CITY OF ALBUQUERQUE
PLANNING DEPARTMENT
DEVELOPMENT REVIEW BOARD

Project# 1010204

14DRB-70288 SITE DEVELOPMENT PLAN FOR BUILDING PERMIT
14DRB-70324 SIDEWALK VARIANCE

RE: Tract Q7A1-A, Atrisco Business Park Unit 4

Los Volcanes Orthodontist
Los Volcanes Rd. NW
LANDSCAPE PLAN

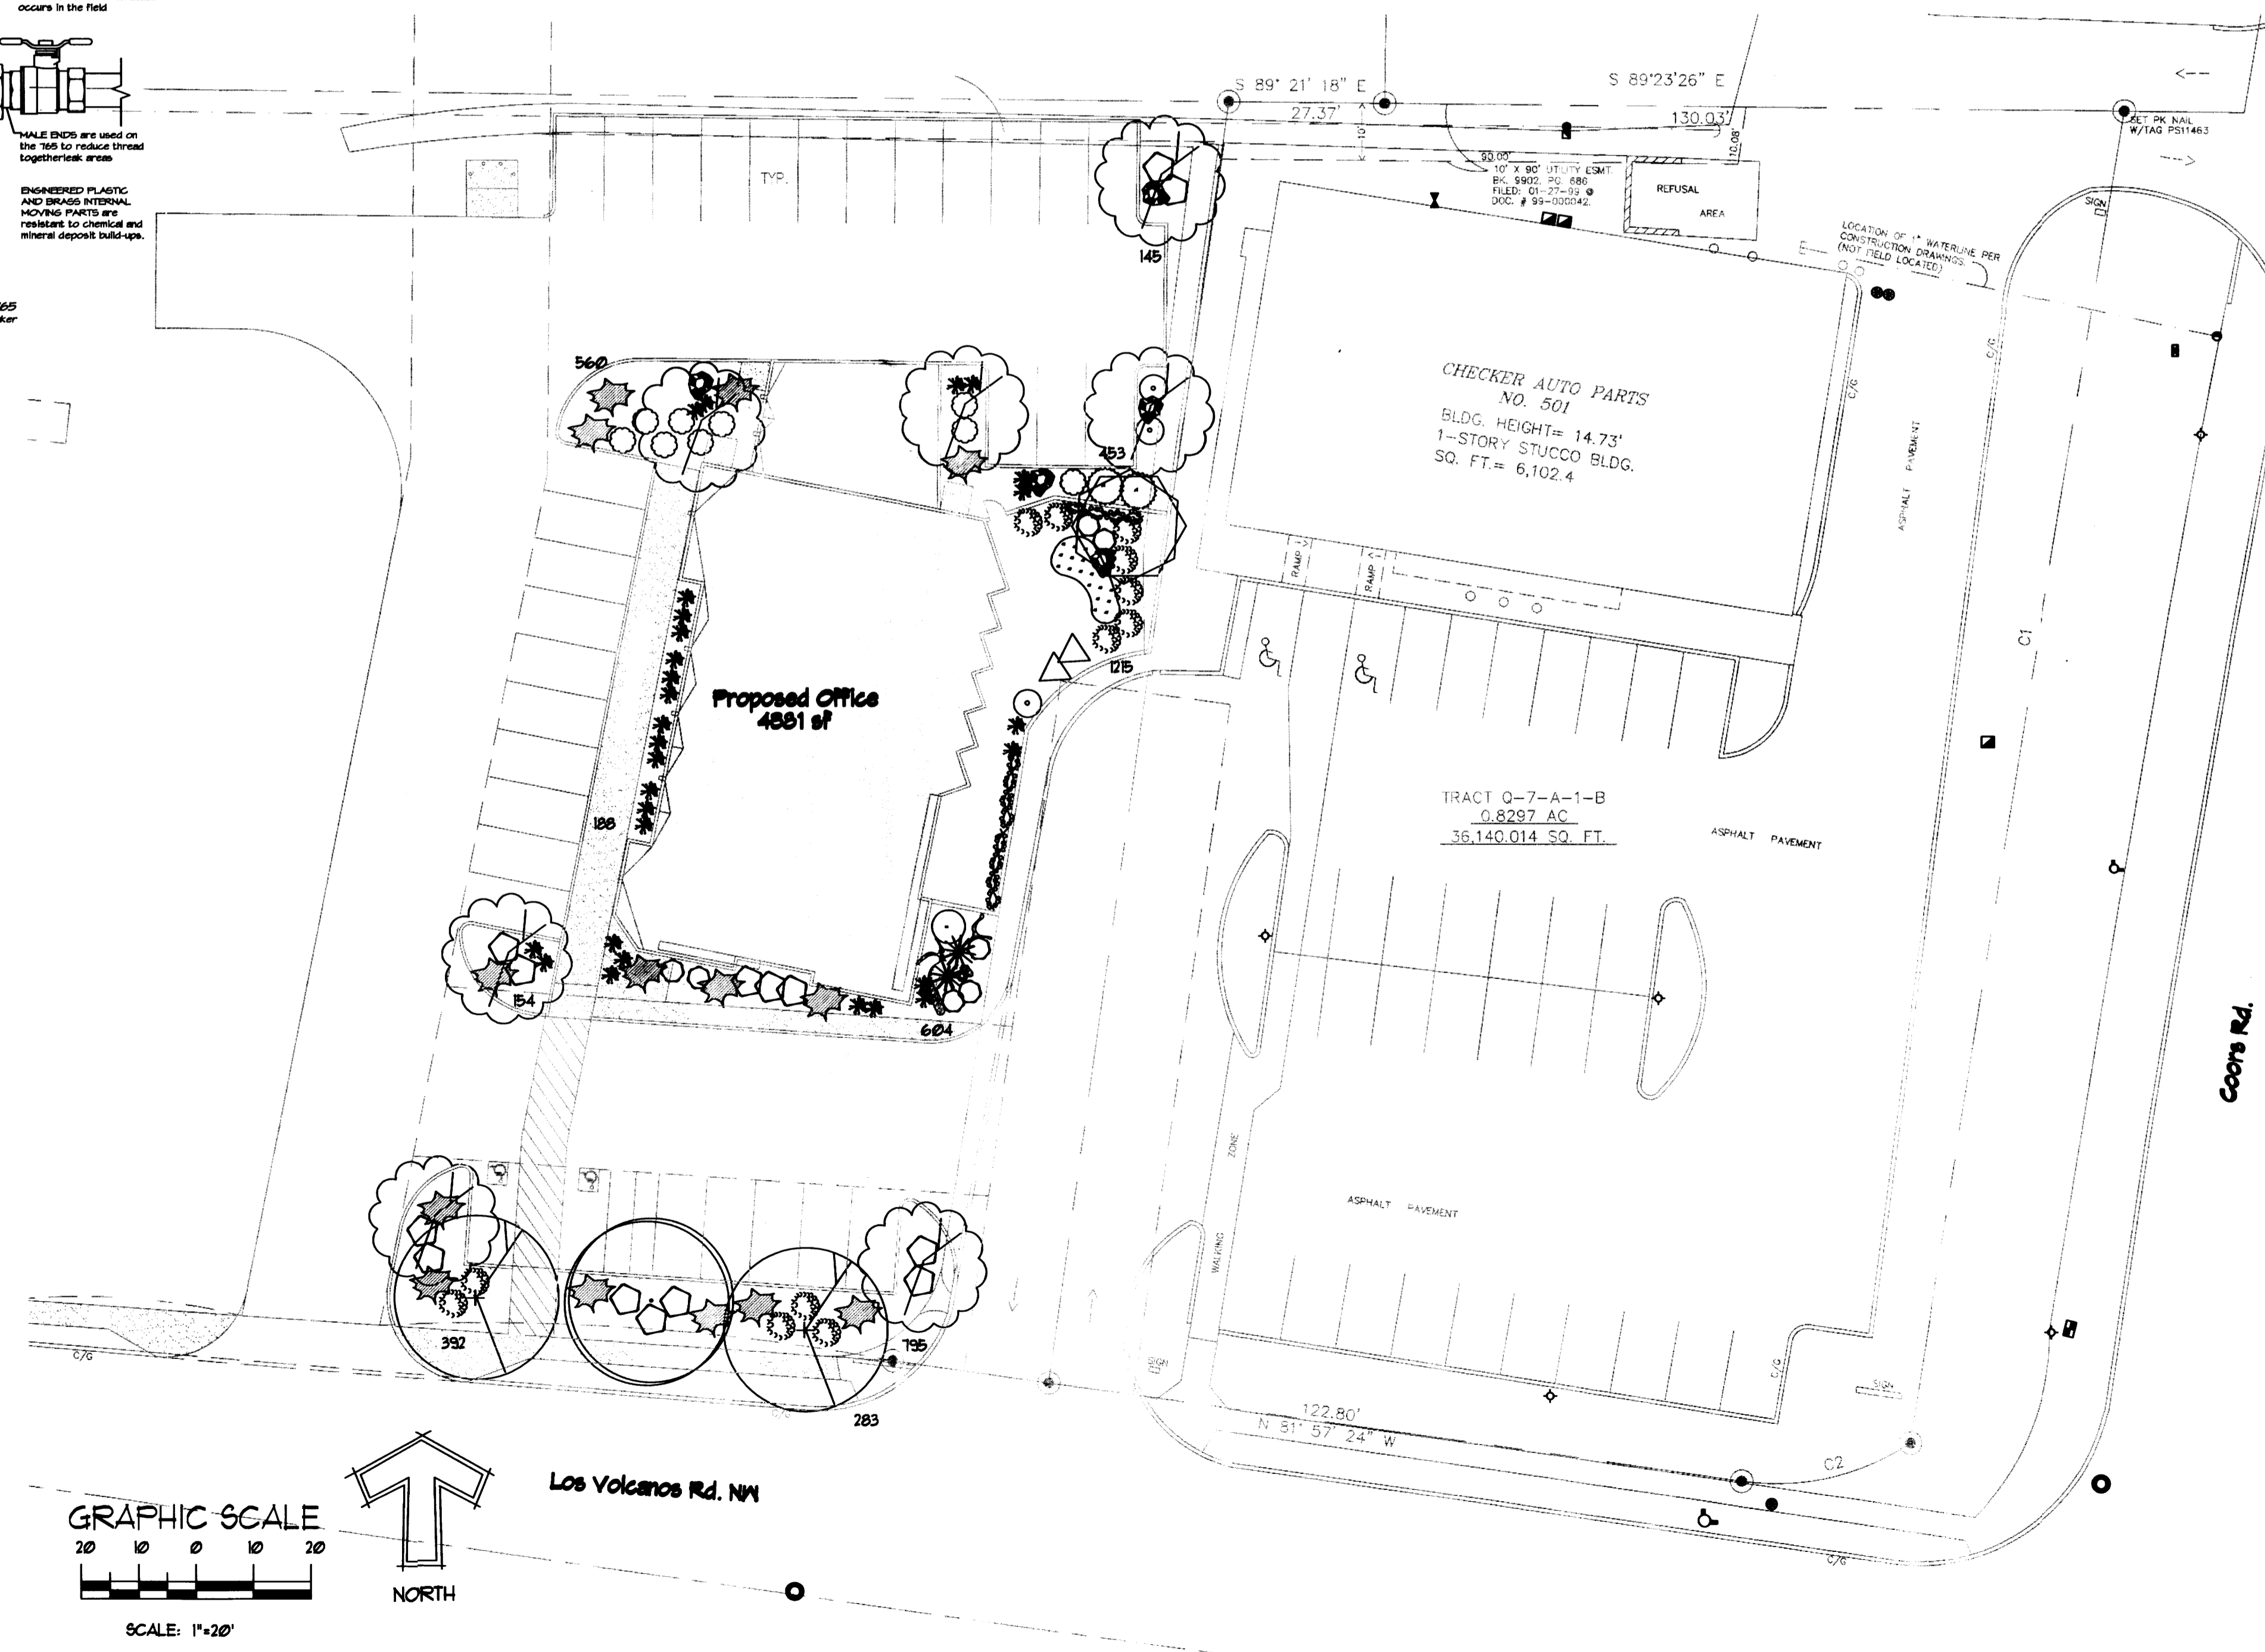
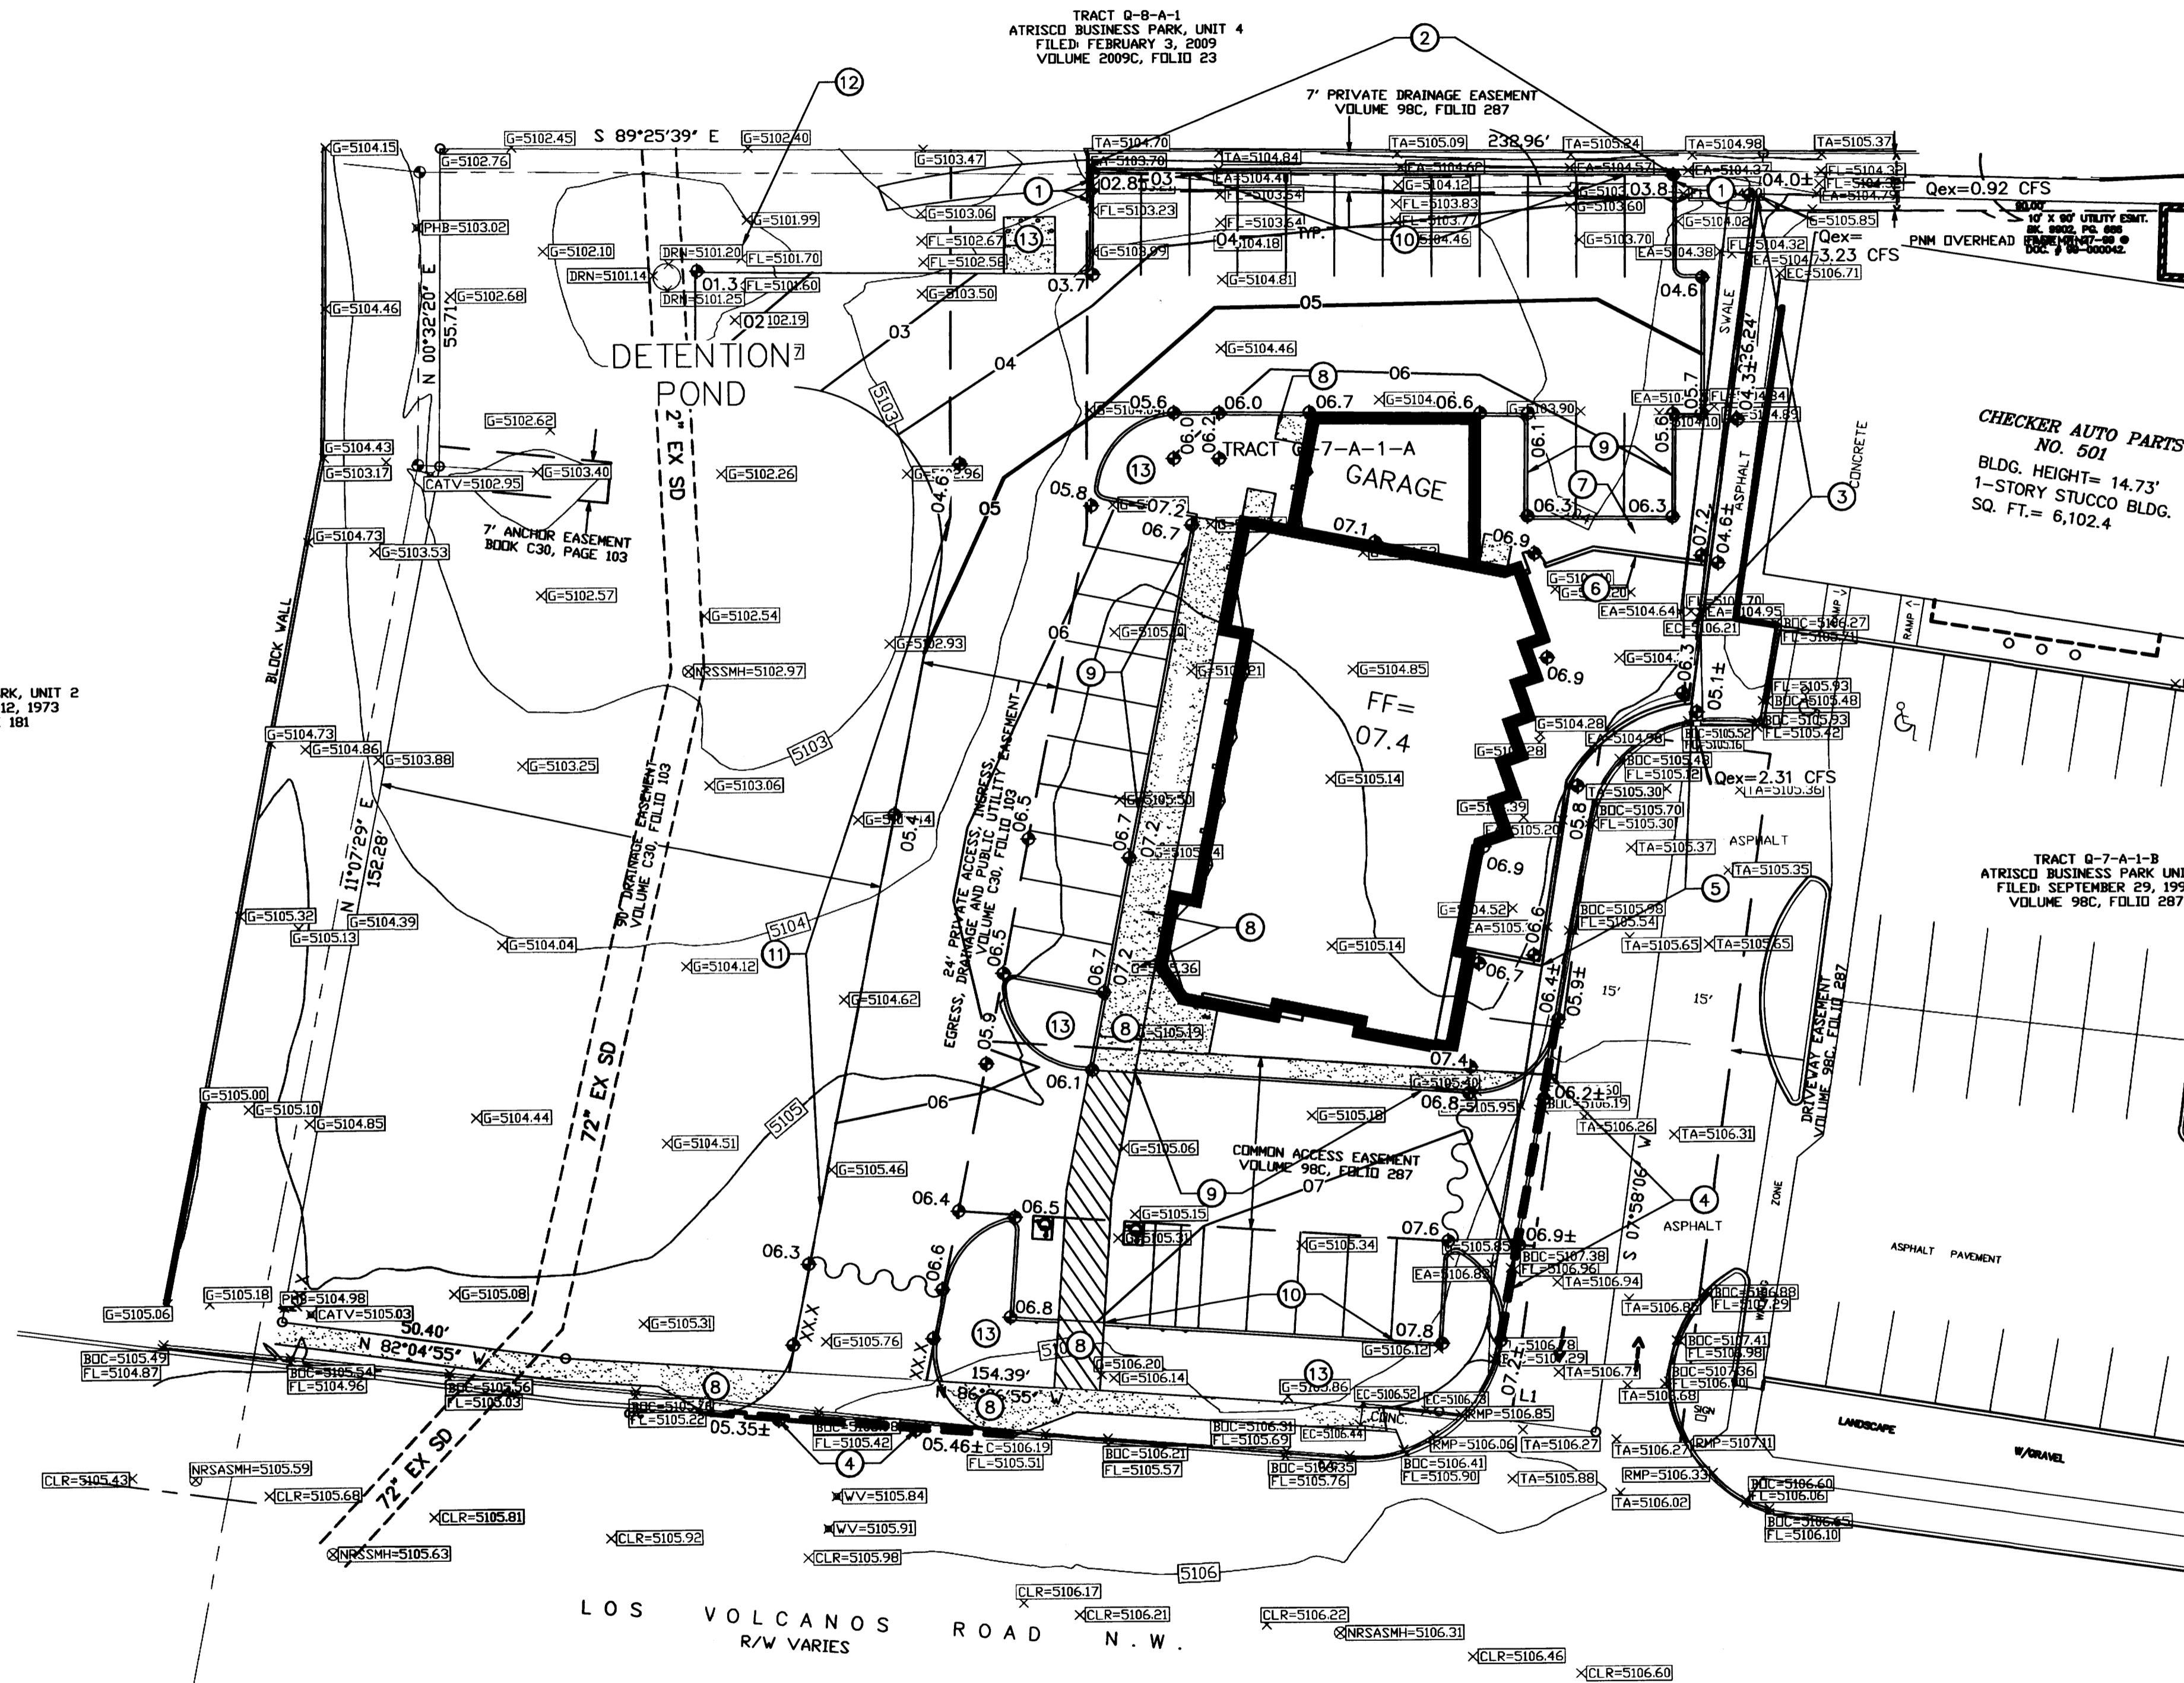
- 1) Recording information of existing easements needs to be noted on the site plan; also note if easements are 'Proposed.'
- 2) Patio wall color/ elevation needs to be noted in the site plan packet.
- 3) Landscape calculation table needs to be for 20% per Master Plan; landscaping is required along the south and east edge of the 90 foot Drainage Easement on the western portion of the site.

- TRANSPORTATION:** _____
- ABCWUA:** _____
- CITY ENGINEER / AMAFCA:** _____
- PARKS / CIP:** _____
- PLANNING (Last to sign):** review Landscape Plan - trees
per Street Tree Ord

PLANNING (Last to sign): review Landscape Plan - trees
OK per Street Tree Ord.

DATE: 11-27-2014
 SHEET NUMBER: CG-1

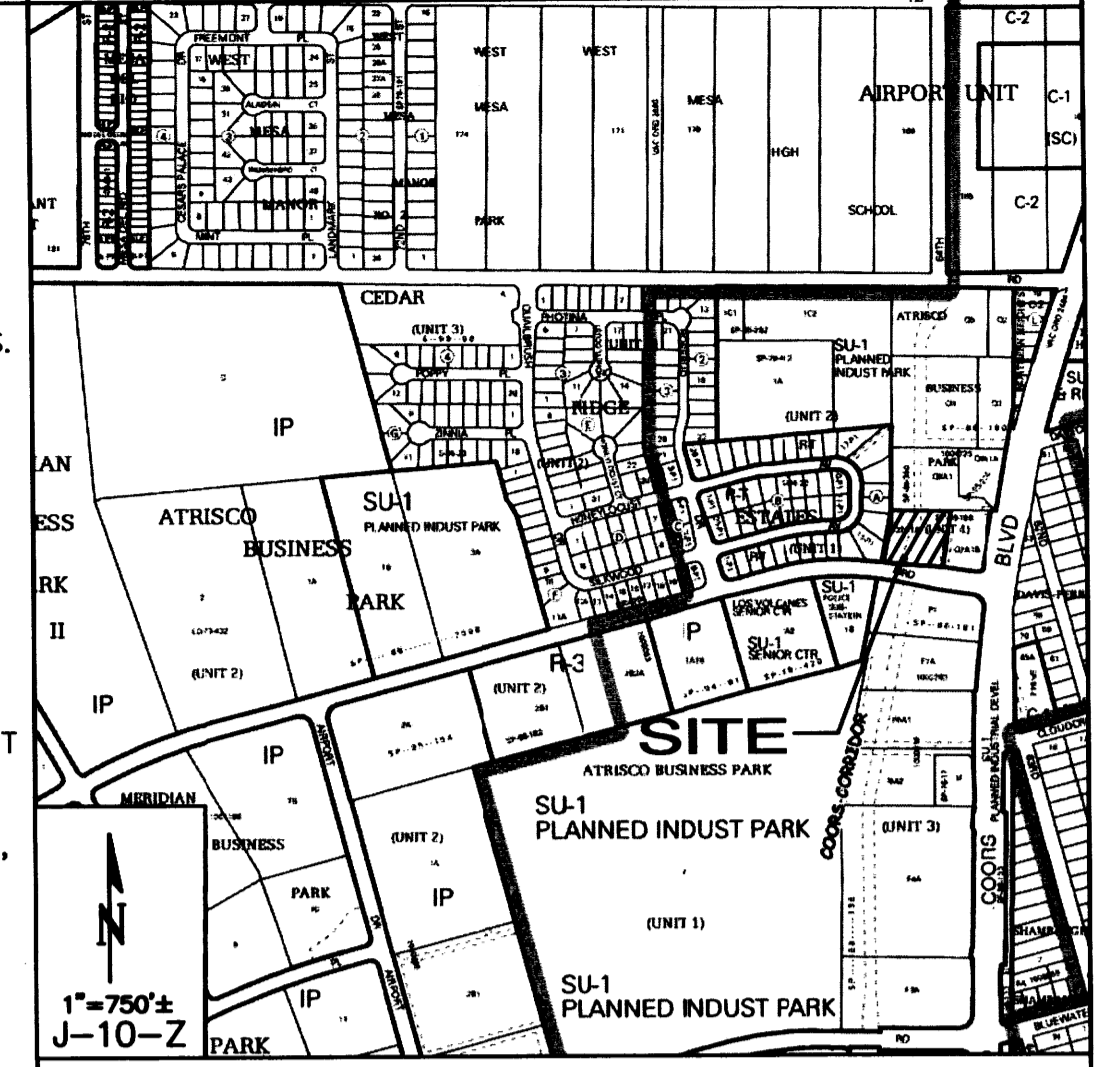
The grading and drainage plan does not match the site plan.

The proposed improvements in the 90 foot drainage easement may conflict with the existing inlet.

Improvements in this area were not shown on the grading and drainage plan.

Resubmit the grading and drainage plan.

This plan proposes work on an adjacent lot. Provide written approval from the property owner to the east.
